The Member Secretary,
Madras Metropolitan
Development Authority,
52, EVK Sampath Road,
MADRAS: 600 007

Ir.No. B1/6927/89

Sub: MMDA - PAA - for proposed residential flats
at D. No. 22 & 23 West road near C.I.T Nagar
near - 35 - ~~near~~ remittance of F.C. / SD & SC
Req - Reg.

MMDA (B)/PP No. 1
 C.No. 21/6927/59
 Scrutiny
 PART I }
 PART II }
 WATER TANK
 (HERMATICALLY & SCIENTIFICALLY CLOSED)

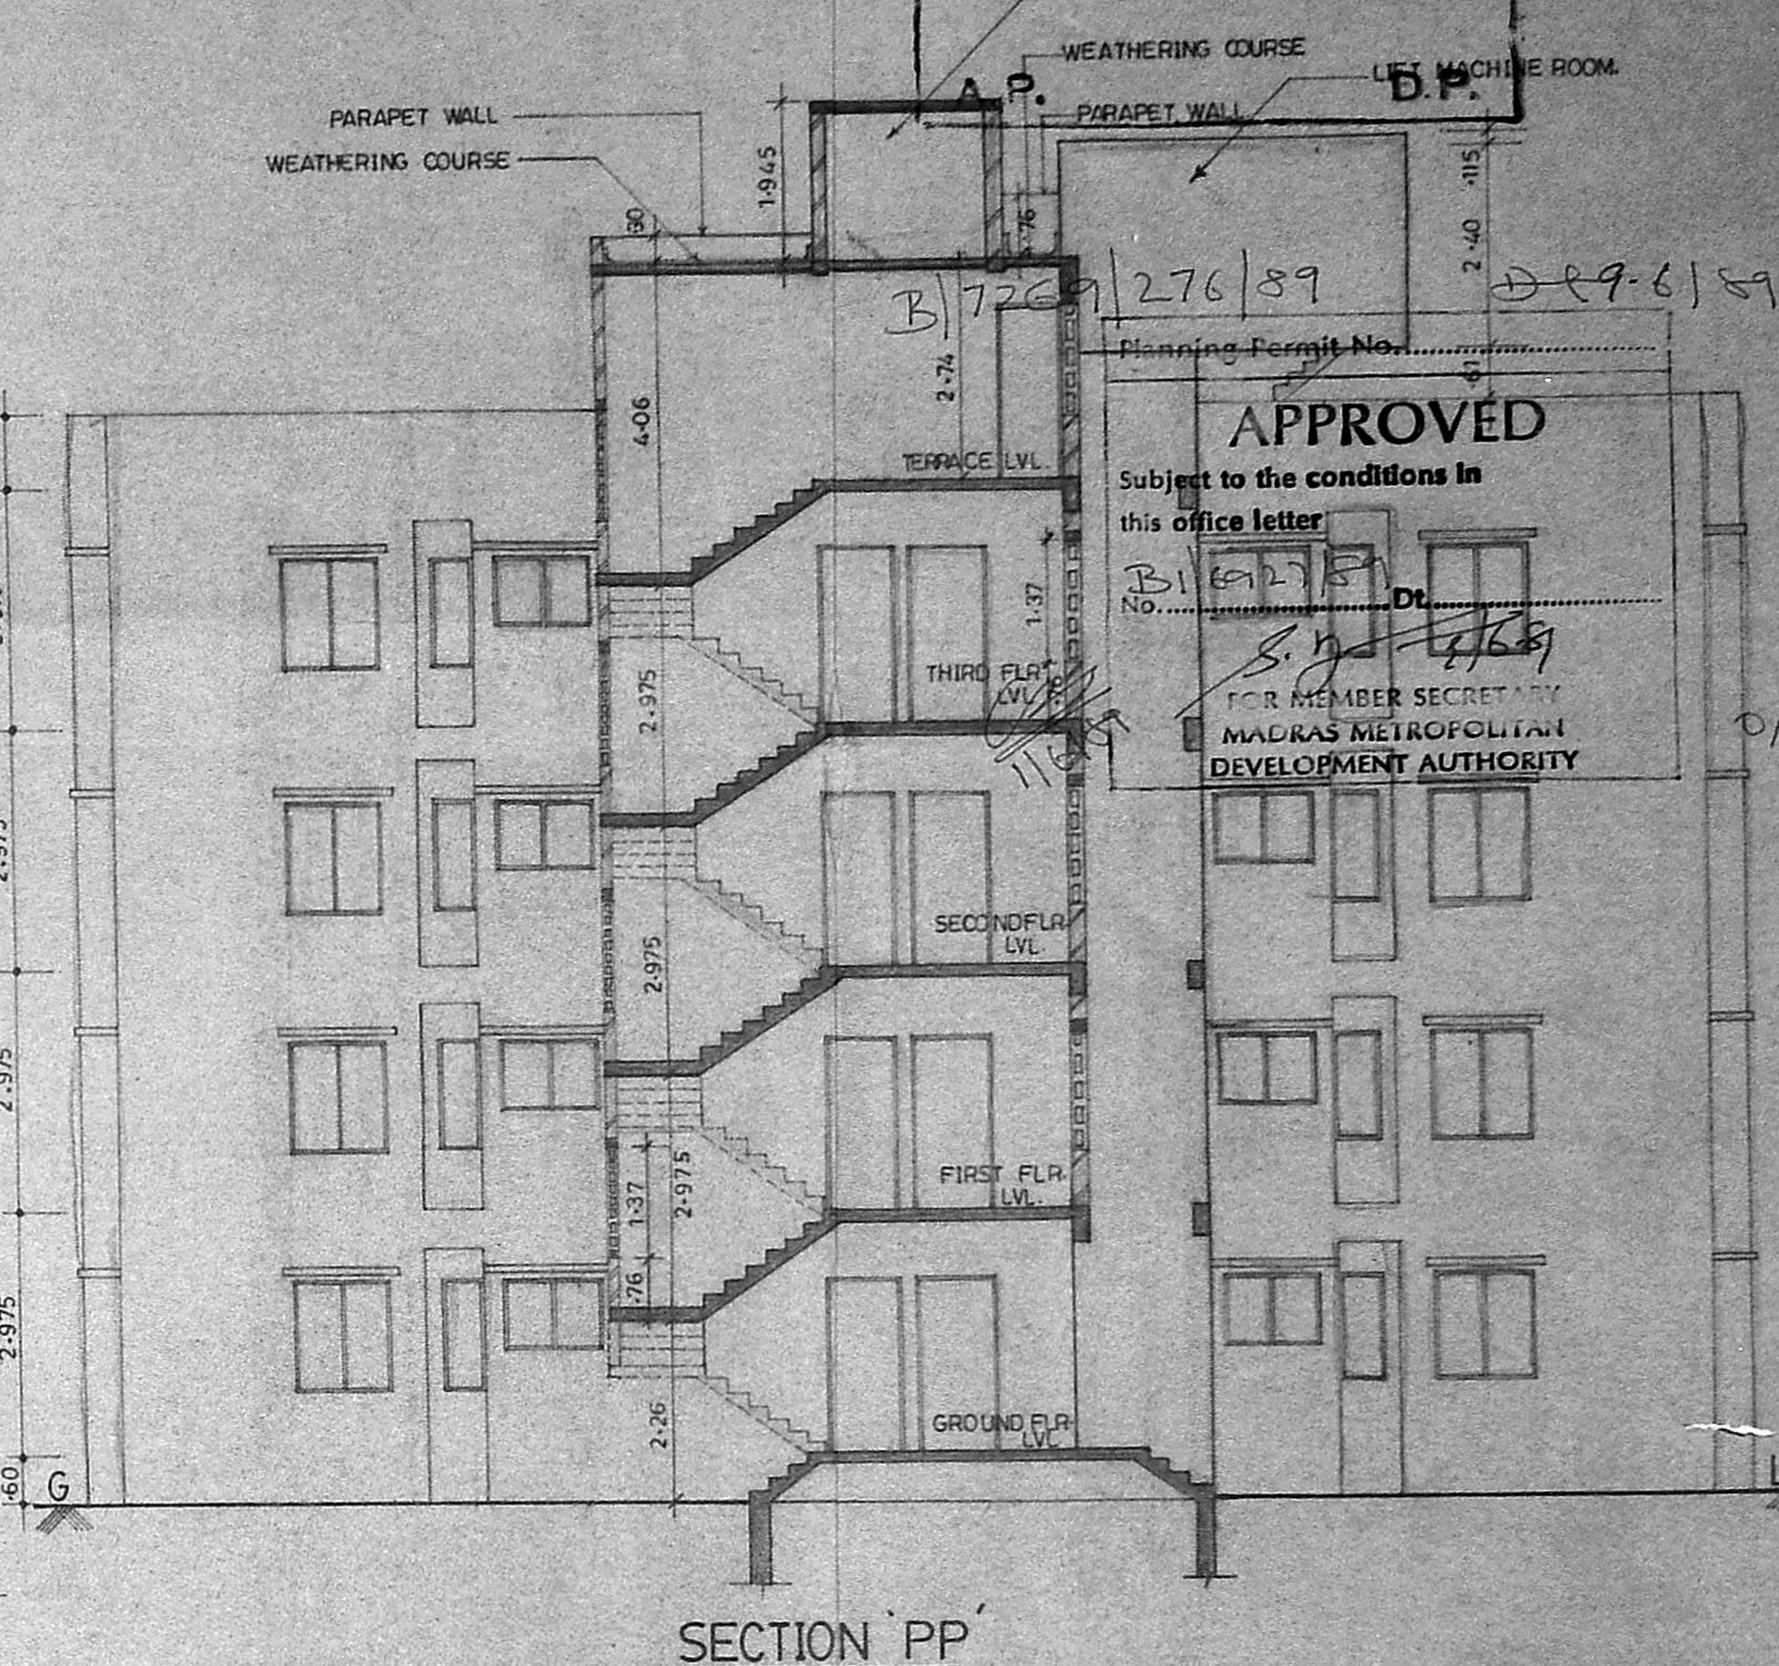
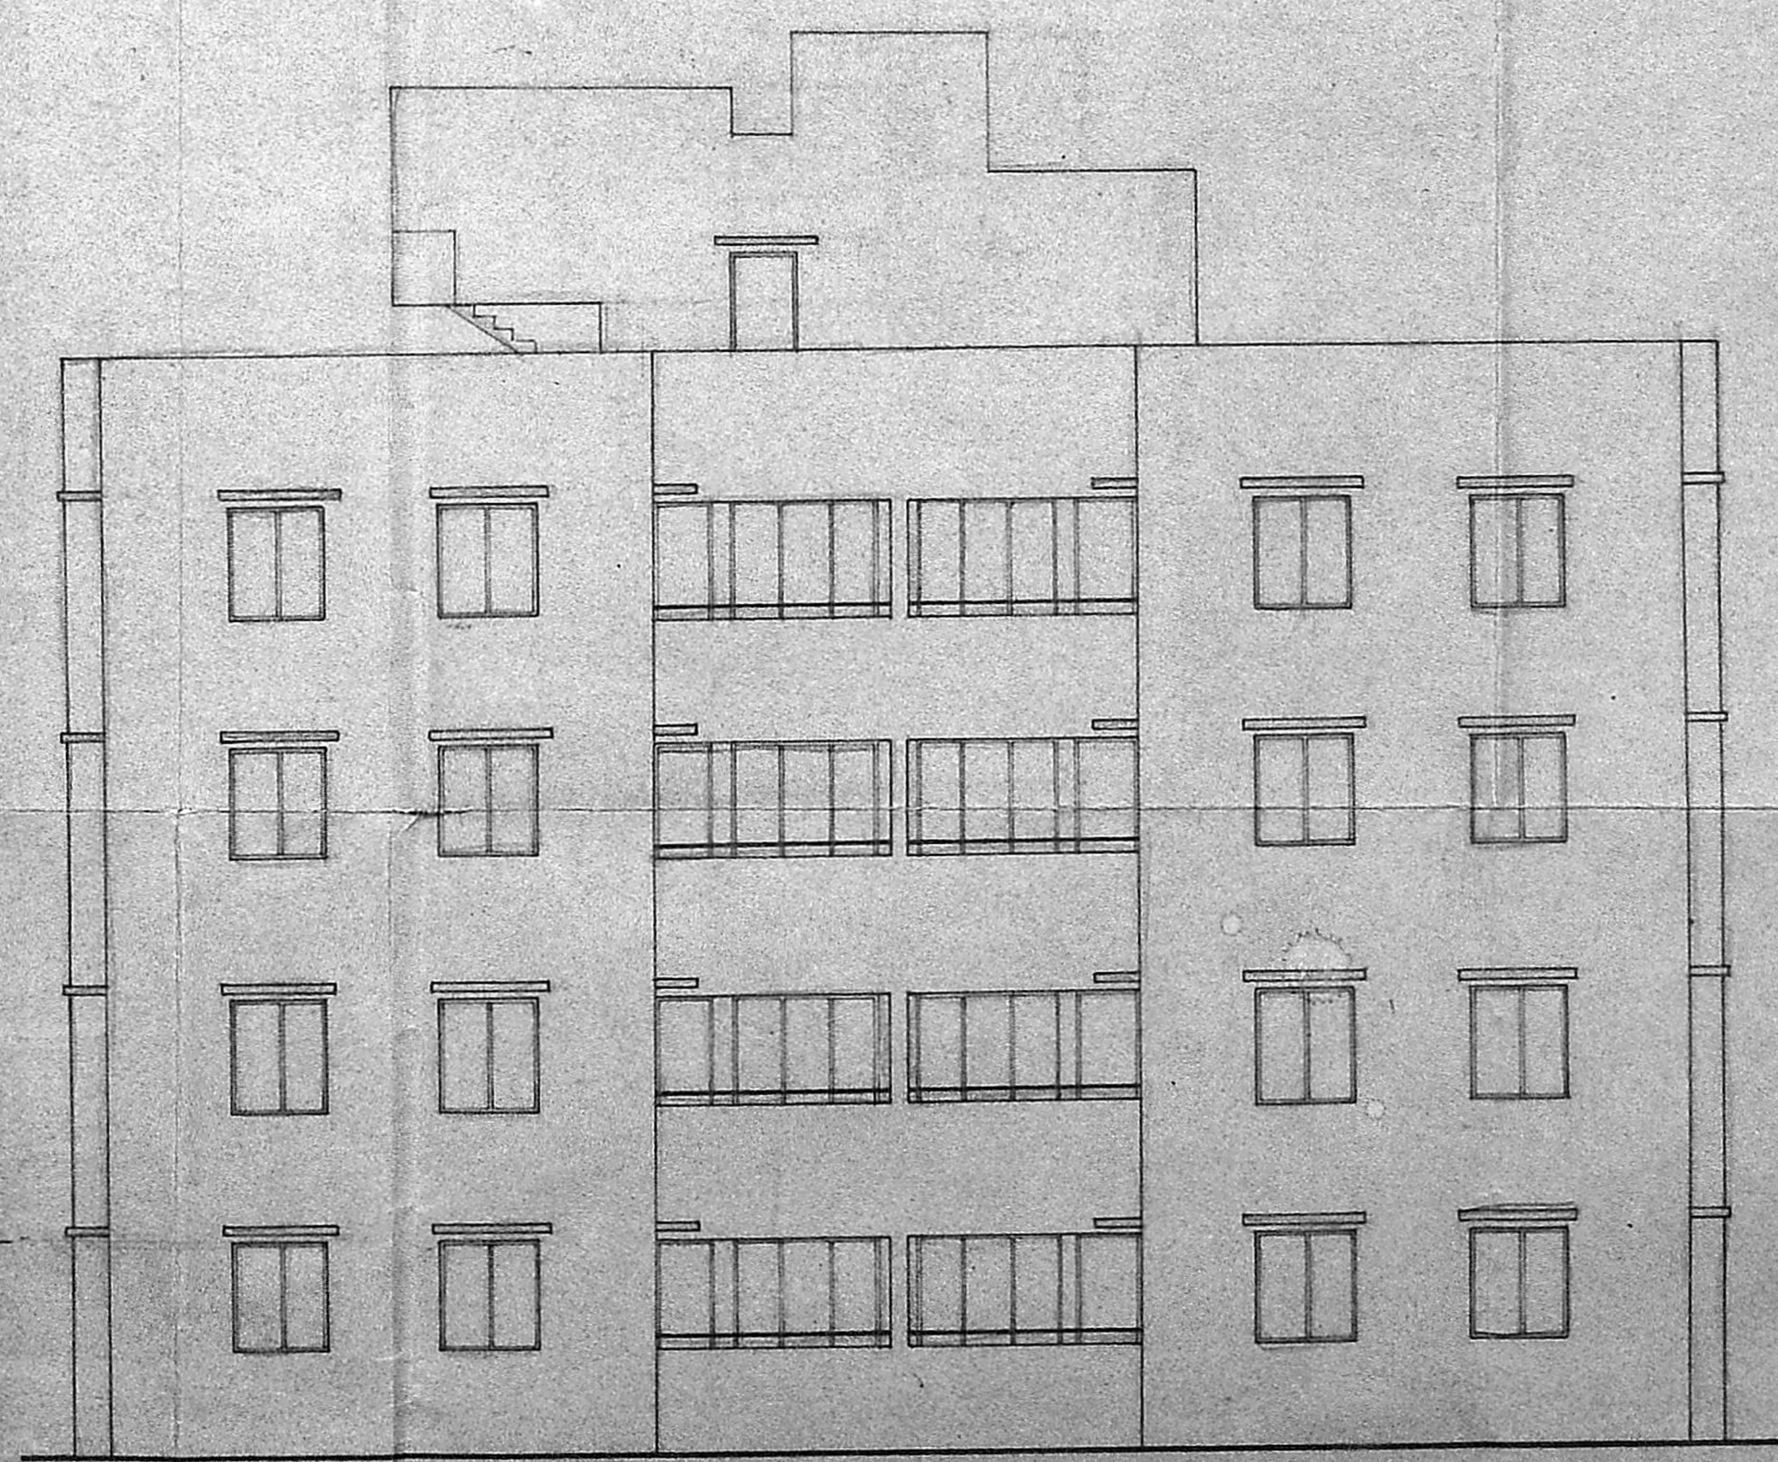
2. Your are requested to provide the O.H.T within the enclosure at 11.60 m.
